CITY OF ALBUQUERQUE

Jaquez and Leticia Cosme: 2460 Camelia Ct SW, Albuquerque, NM 87105
Cosme Retail: 6205 Central Ave NW

Re: Drainage Ordinance (14-5-2-1) Issues for Erosion and Sediment Control

DATE	REVISION	LOT C-151A, BLOCK 2, TOWN OF ALBUQUERQUE, BERNALILLO COUNTY, NEW MEXICO
		6205 CENTRAL AVE NW
		RETAIL SUITES
		Erosion & Sediment Control Plan

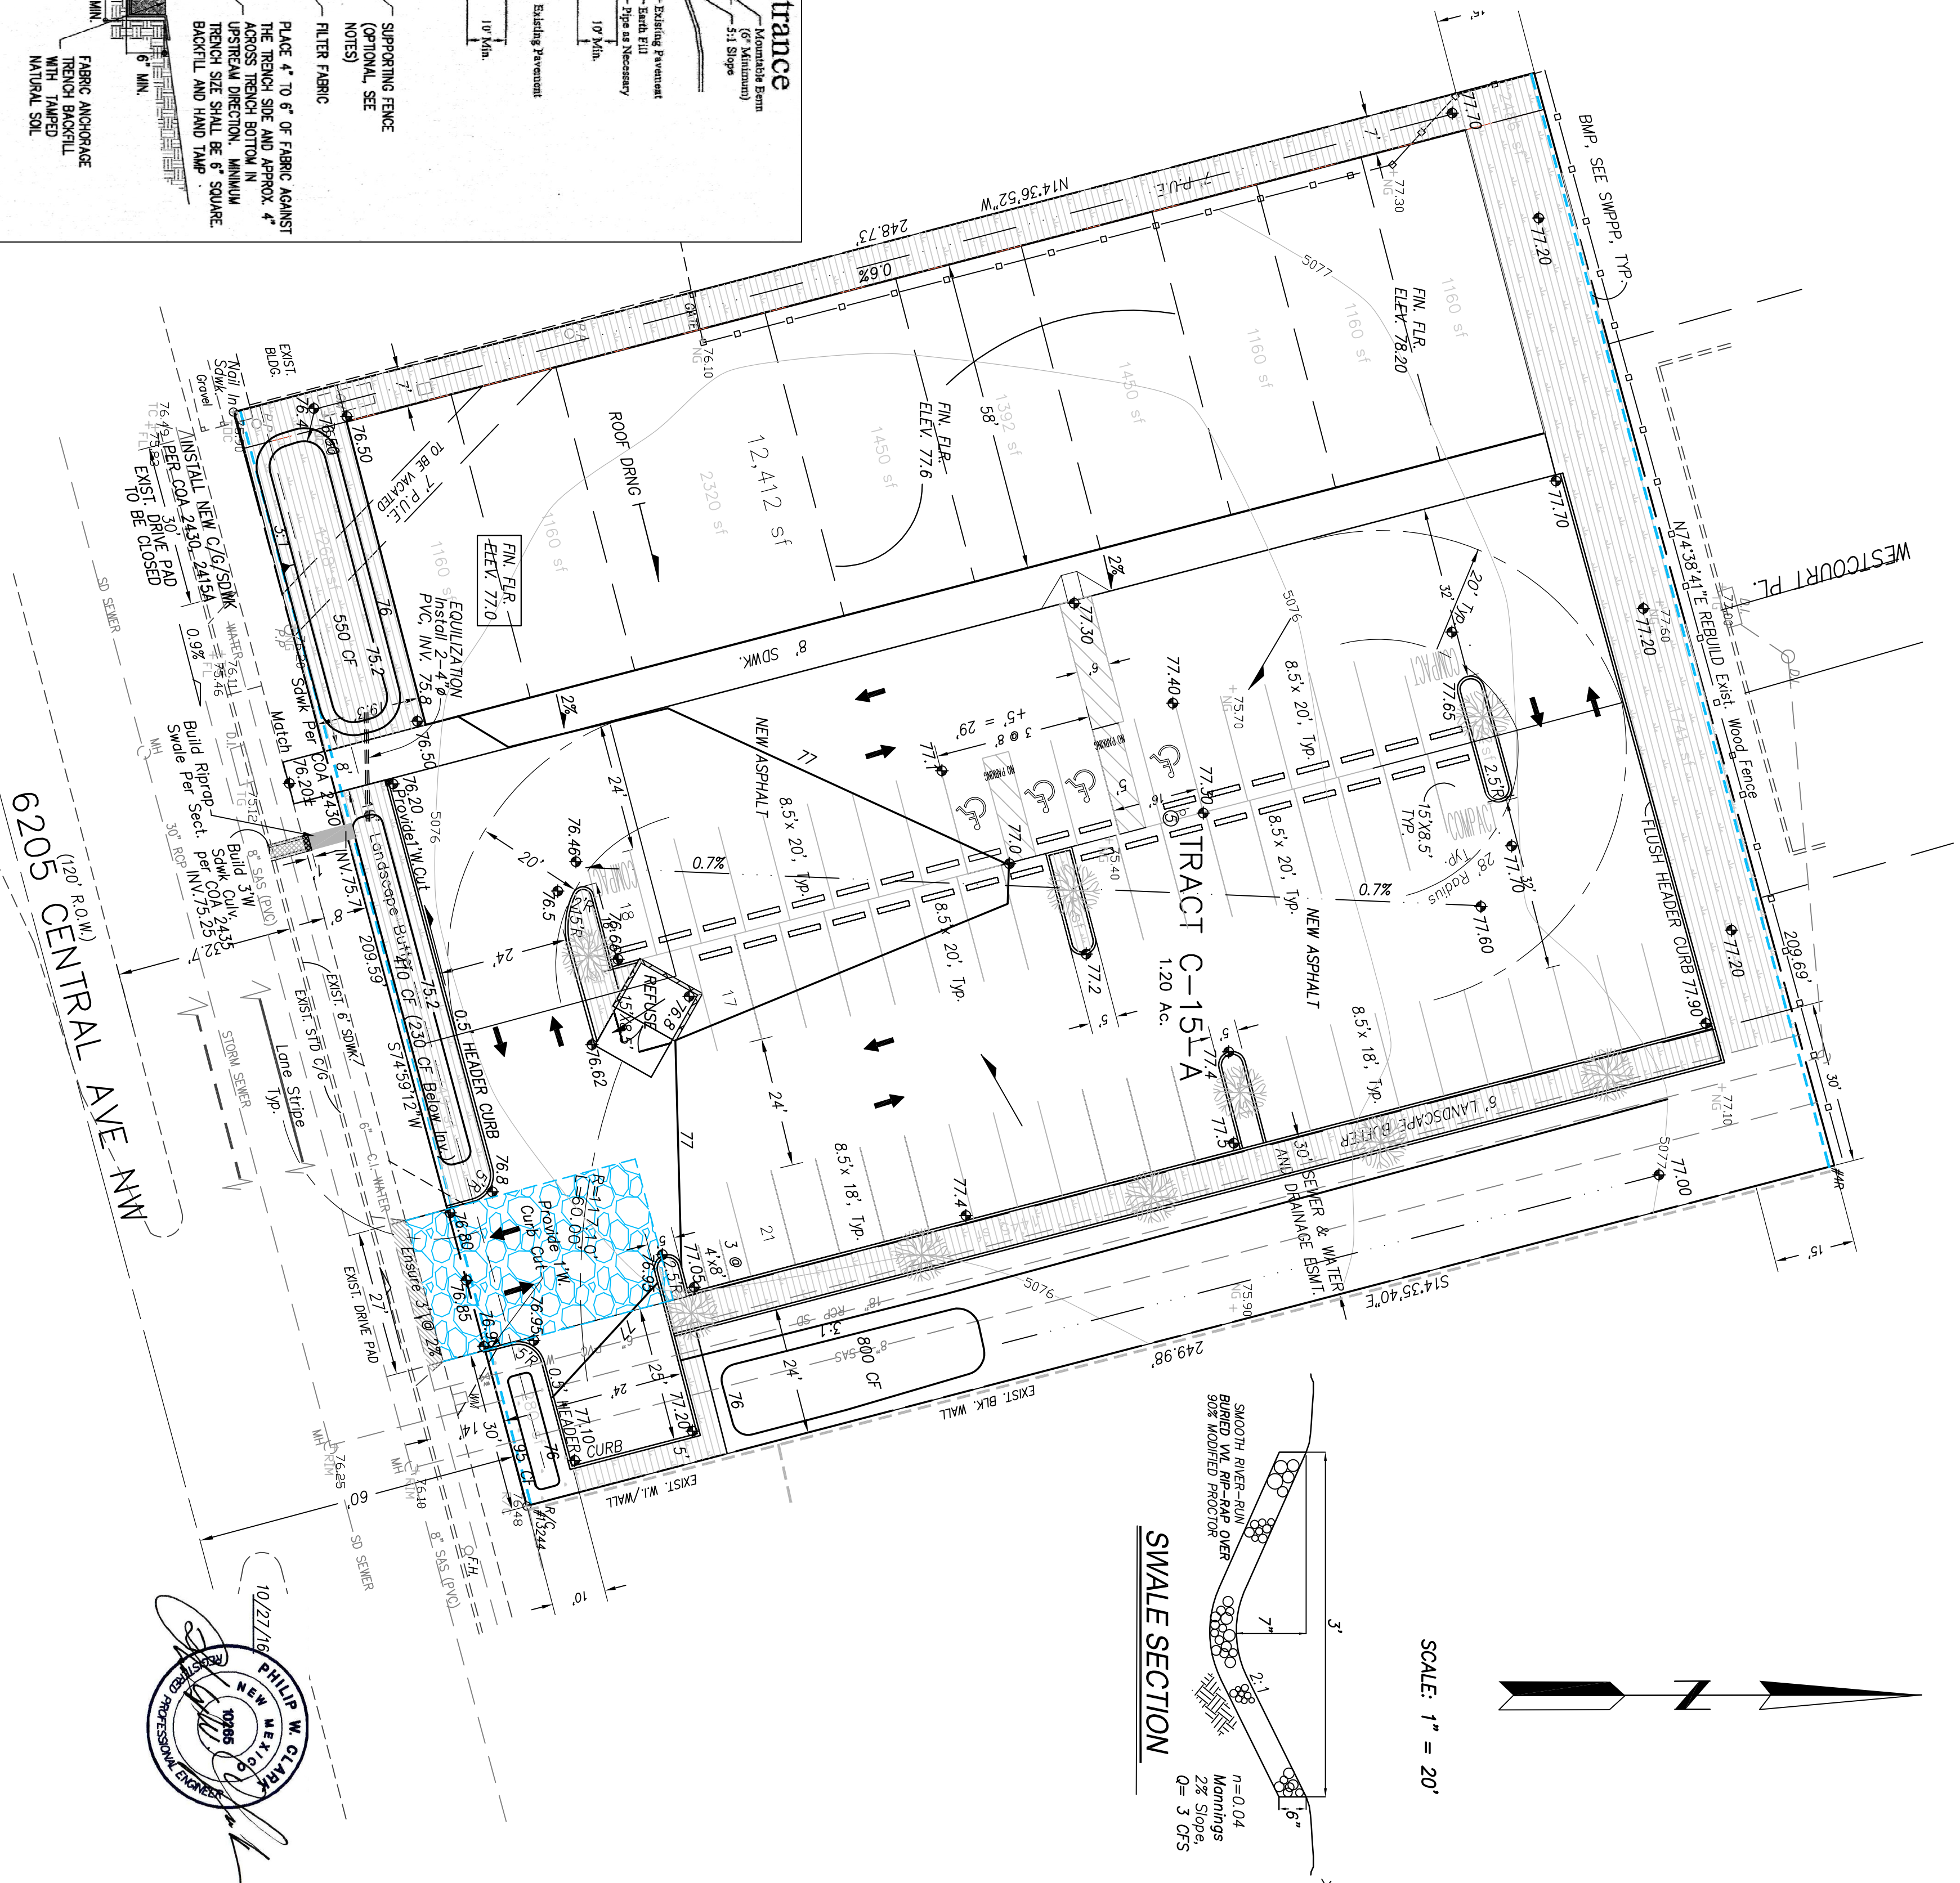
1. Along Central Ave, there was a missing section of silt fence and the silt fence that is installed is installed incorrectly.
2. There was windblown dirt on the sidewalk and in the gutter on Central Ave.
3. There was no stabilized construction entrance.
4. There was trash all over the site.
5. There was a pile of dirt behind (West) the building and no sediment BMP to prevent the dirt from going into the adjoining property.

1. Properly install silt fence along Central Ave per the approved Erosion and Sediment Control plan.
2. Remove dirt from sidewalk and gutter on Central Ave. in front of the project.
3. Install a stabilized construction entrance per the approved Erosion and Sediment Control plan.
4. Remove trash.
5. Remove the pile of dirt behind (West) the building or provide a sediment BMP to prevent the dirt from going into the adjoining property.
